**Planning application no. 3.24.101**

**Proposal: Proposed two-storey, triple garage with home office on first floor.**

**Resubmission of 3.2023.0787**

**Location: Bridge End Cottage Rimington Lane Rimington BB7 4EA**

Location and Block Plans

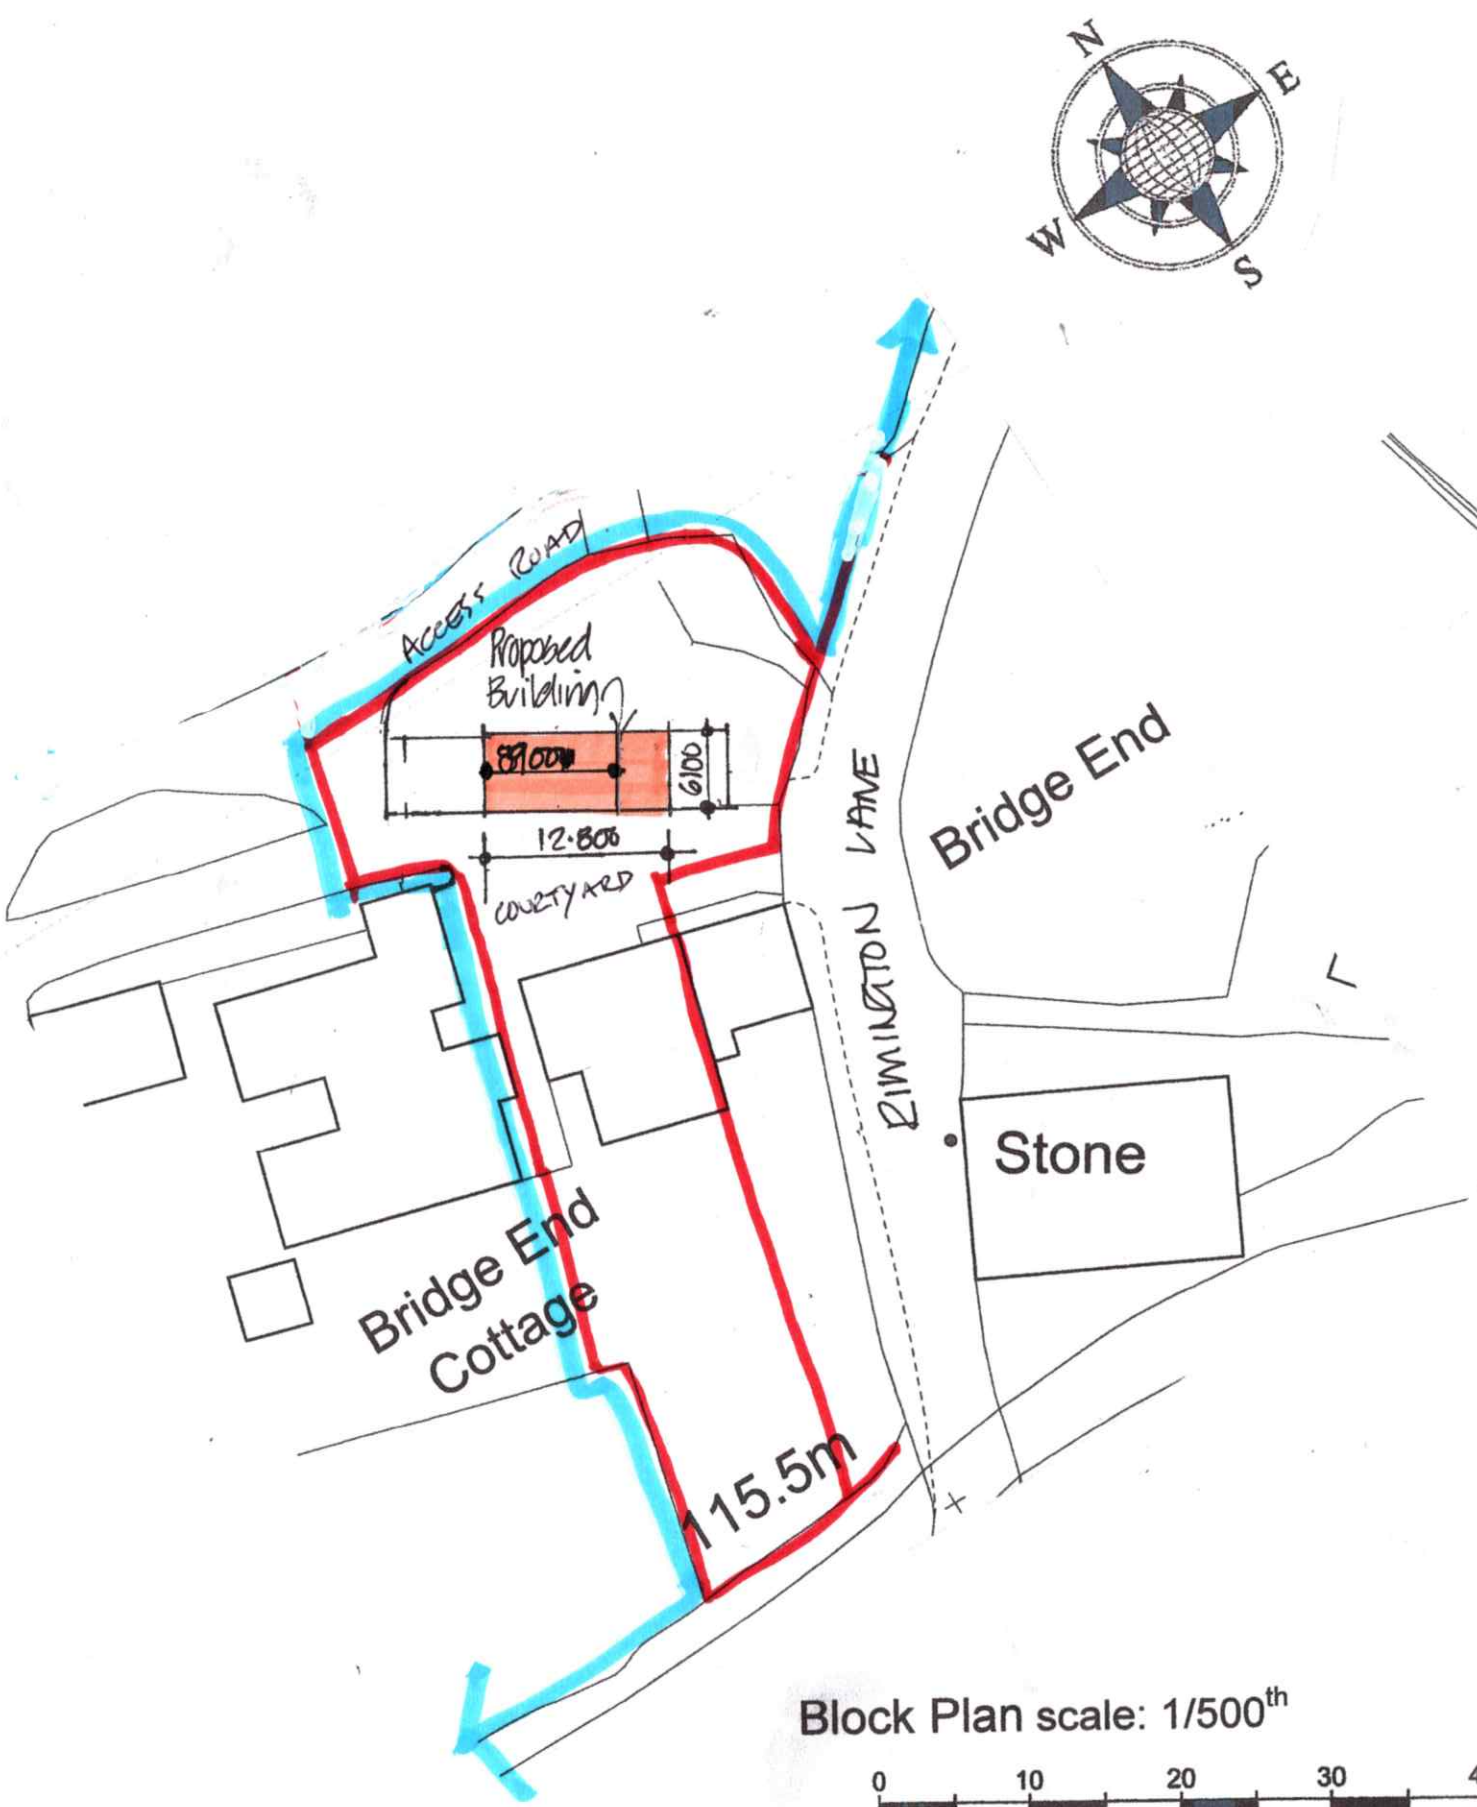
Public Right of Way FP0336019 should not be obstructed during construction works.
